RE: Oxley Solar Farm (SSD-10346) Armidale Regional Council

Attachment 1: Detailed BCD Comments – Oxley Solar Farm (SSD-10346)

Biodiversity Development Assessment Report

Figure 1-3 Development Footprint

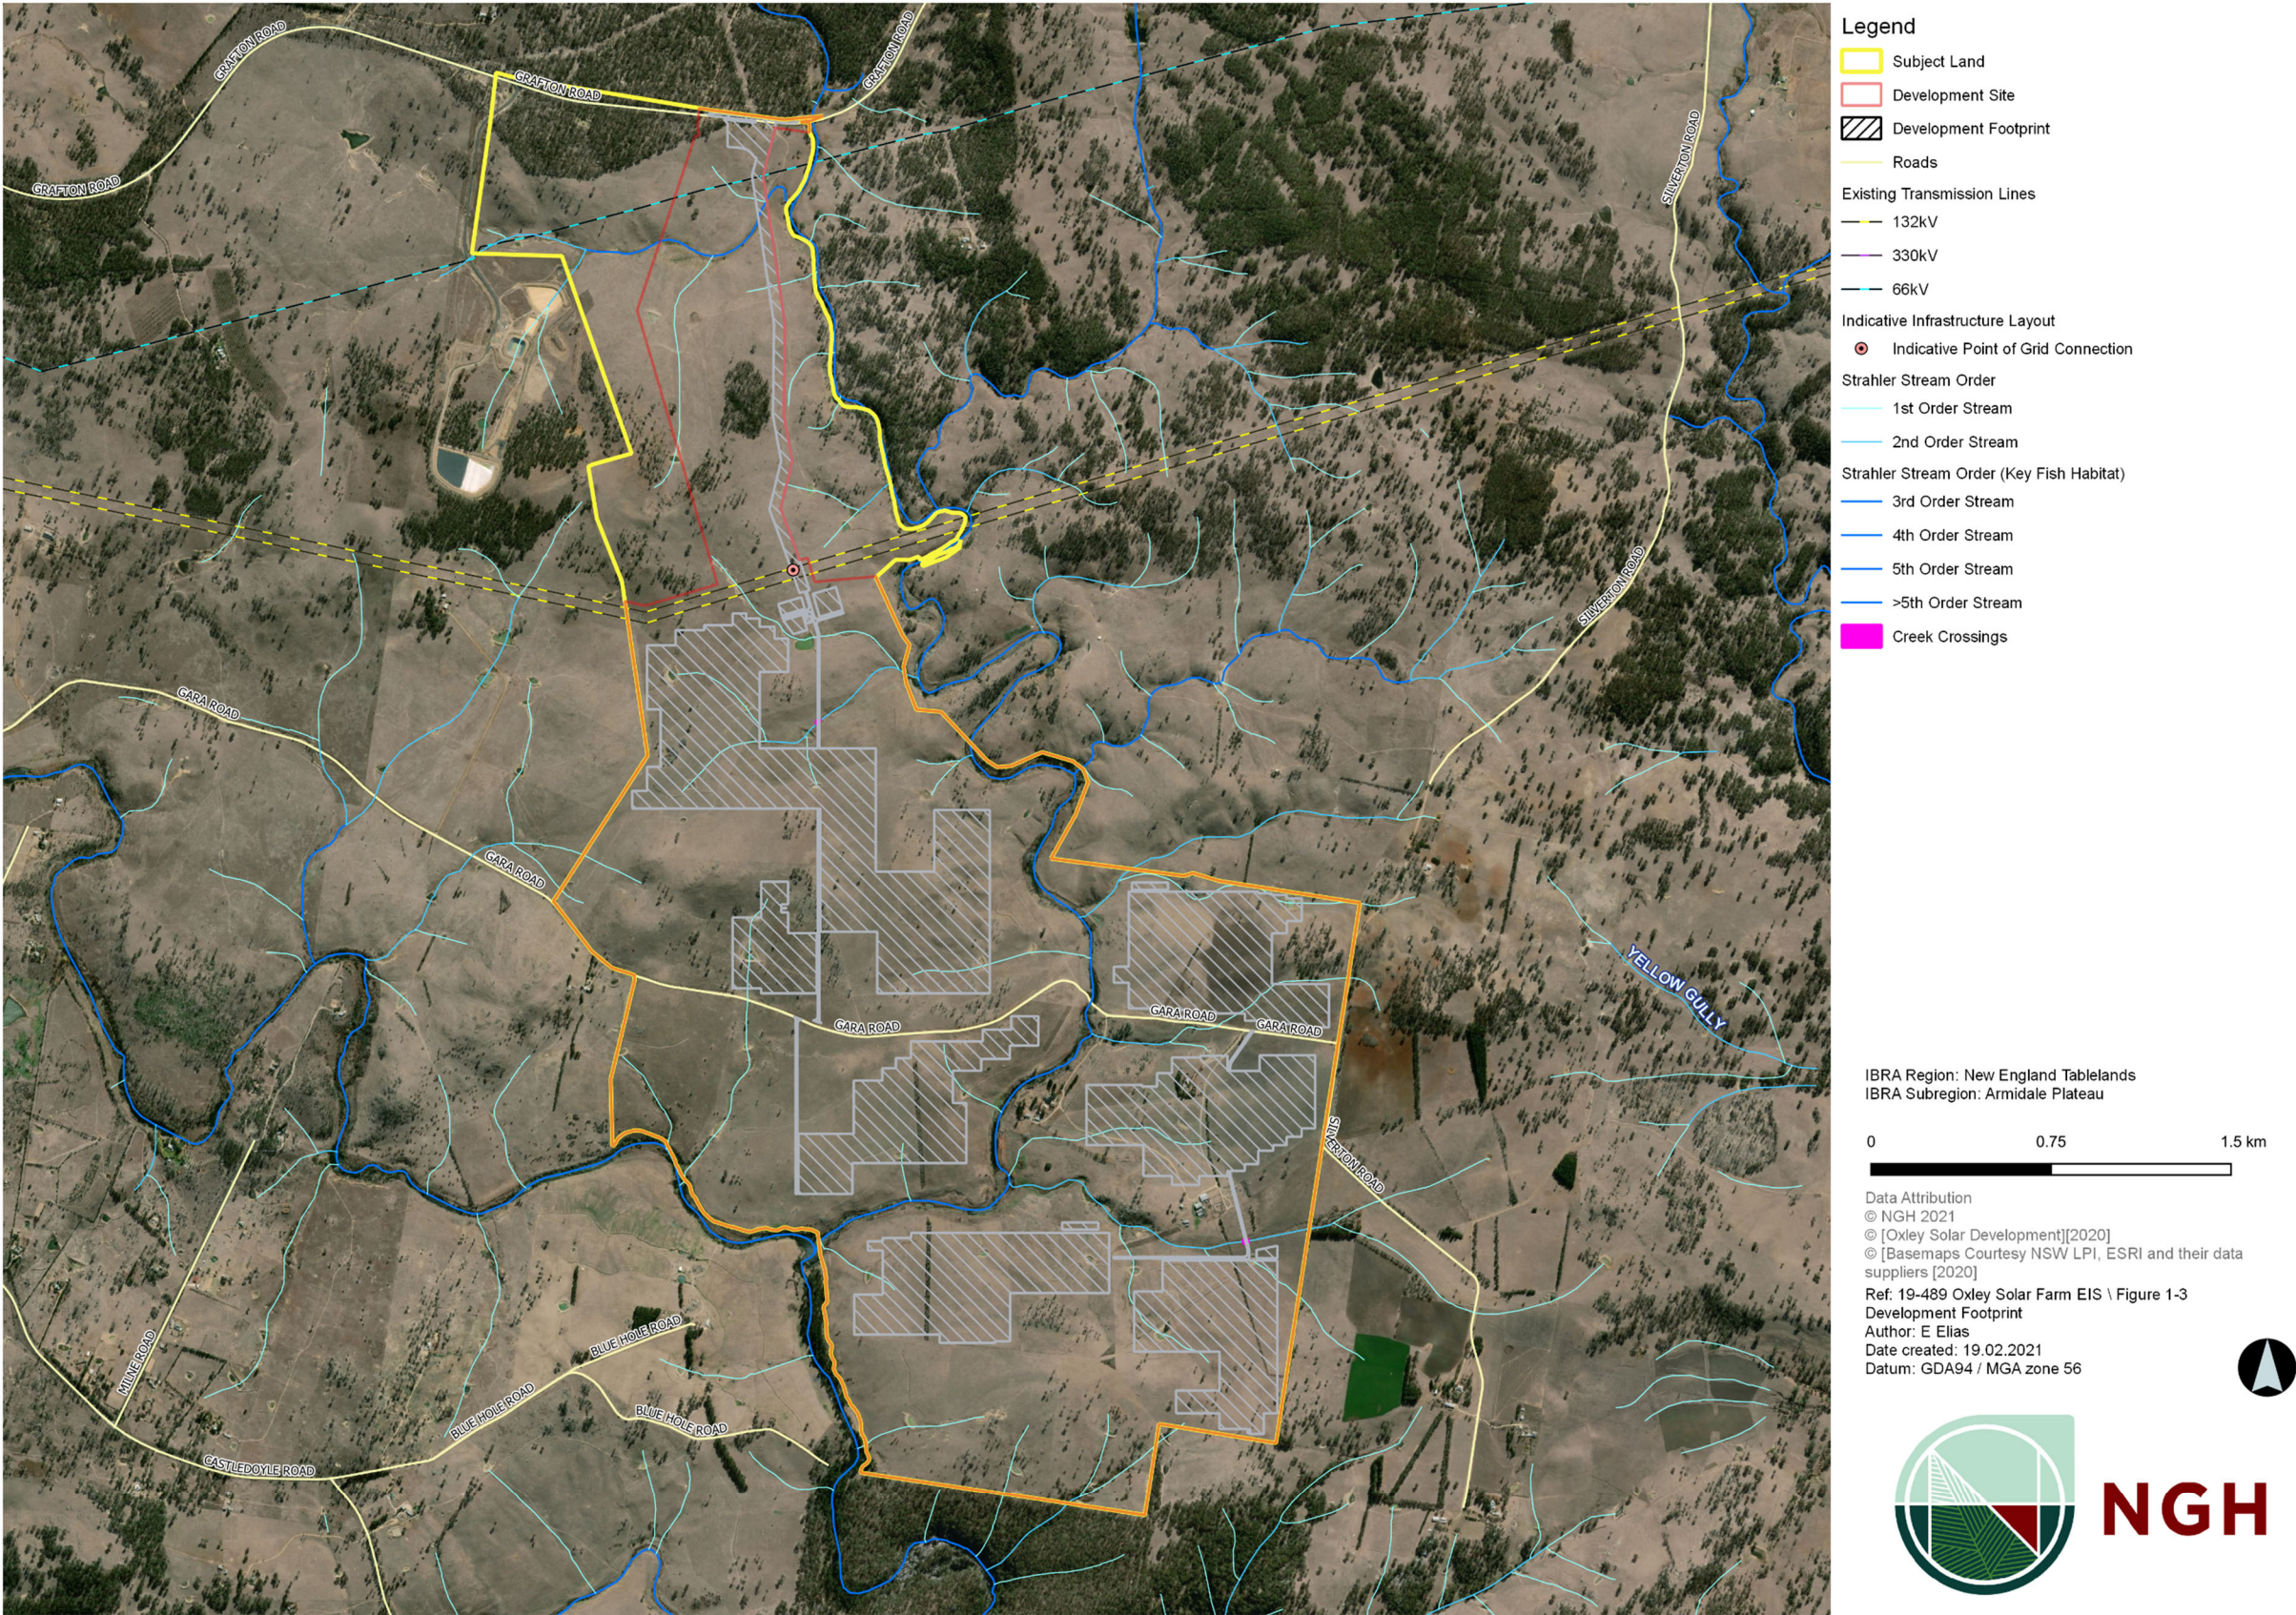
All direct impacts of the proposal are shown in figure 1-3 of the BDAR, which identifies the development footprint. An indirect impact zone should be identified around the development footprint.

We note that mitigation measures have been identified in section 8 of the BDAR to address any potential indirect impacts. If the BDAR cannot demonstrate that all indirect impacts have been effectively mitigated, then biodiversity credits should be calculated for the remaining indirect impacts in accordance with the BAM Operational Manual Stage 2.

4. Further consideration must be given in the BDAR to identifying indirect impacts immediately adjacent to the development footprint and determining whether biodiversity credits are required to offset these impacts.

Figure 2-2 Native vegetation extent within 1500m buffer area

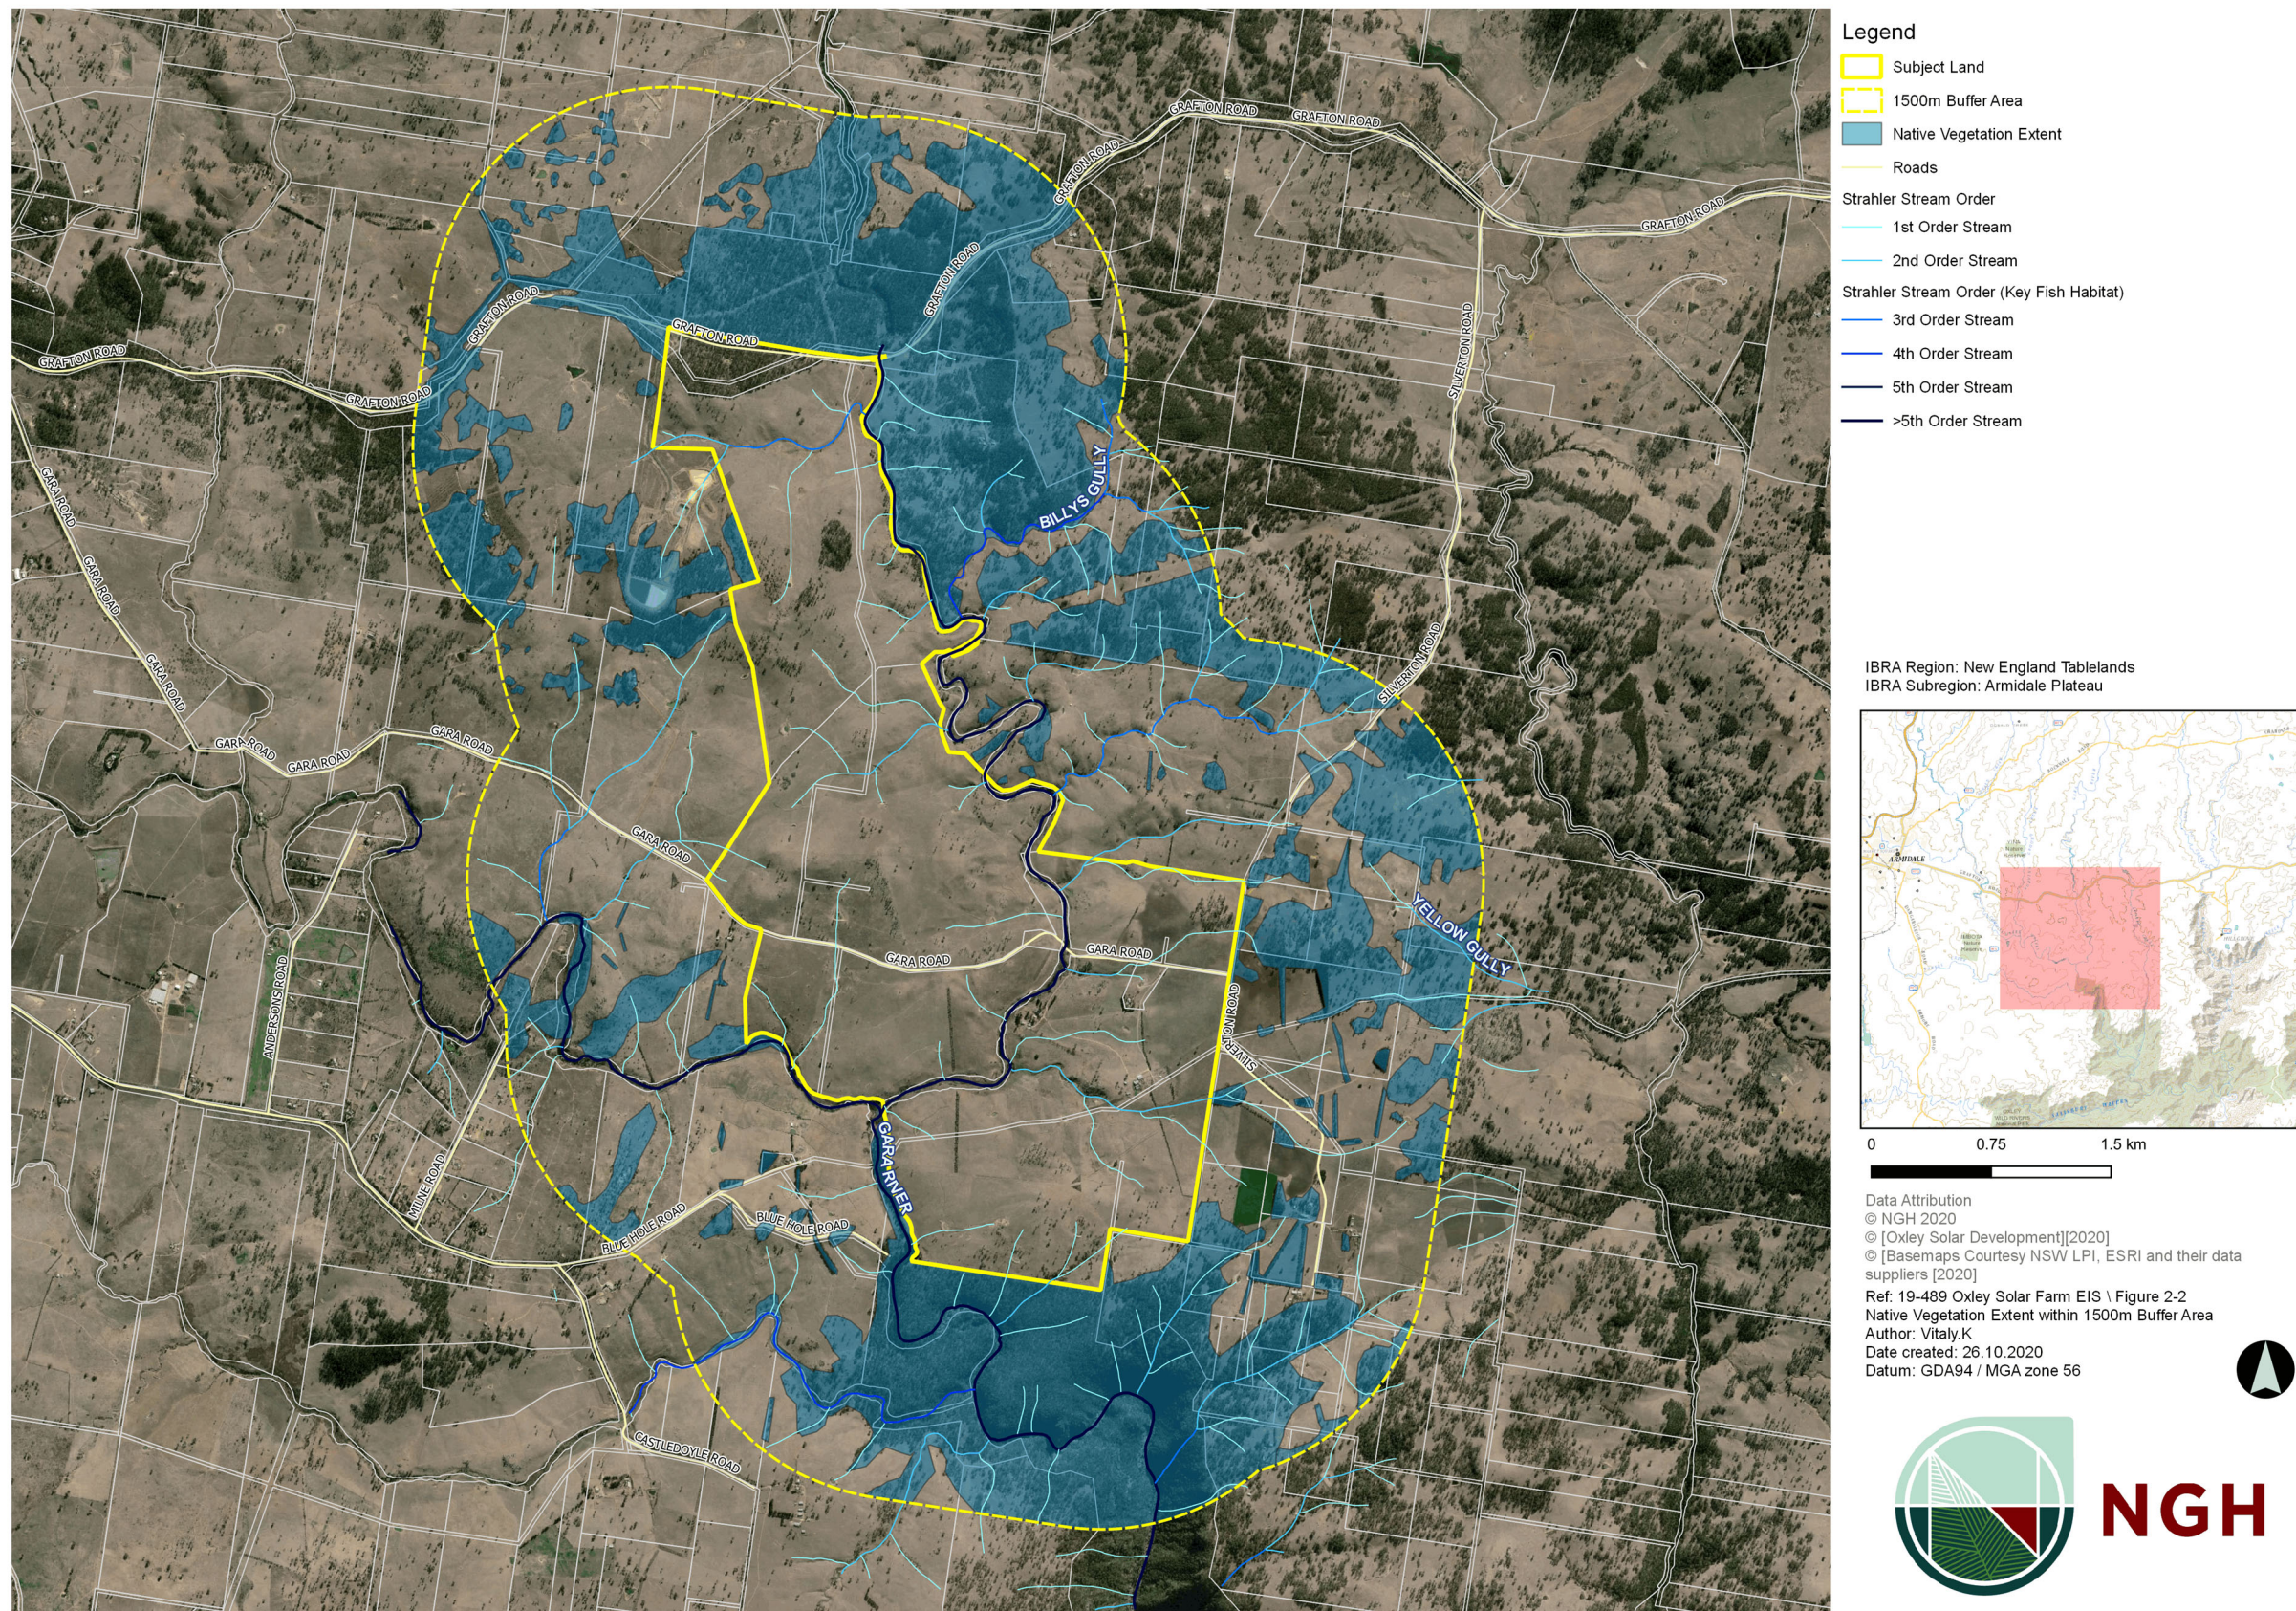
Figure 2-2 of the BDAR shows the mapped native vegetation cover for the 1500m buffer area. This native vegetation cover assessment is a requirement of the Biodiversity Assessment Method (BAM) and is used in the BAM calculator to filter predicted threatened species likely to occur.

In accordance with page 8 of the BAM Operational Manual Stage 1, the percent of native vegetation cover is to include the total area of the subject land and the buffer. The BDAR appears to only have assessed the native vegetation cover for the buffer area. This assessment also needs to include native vegetation cover for the subject lands.

1. The native vegetation cover assessment must include the subject land in accordance with the BAM operational manual.
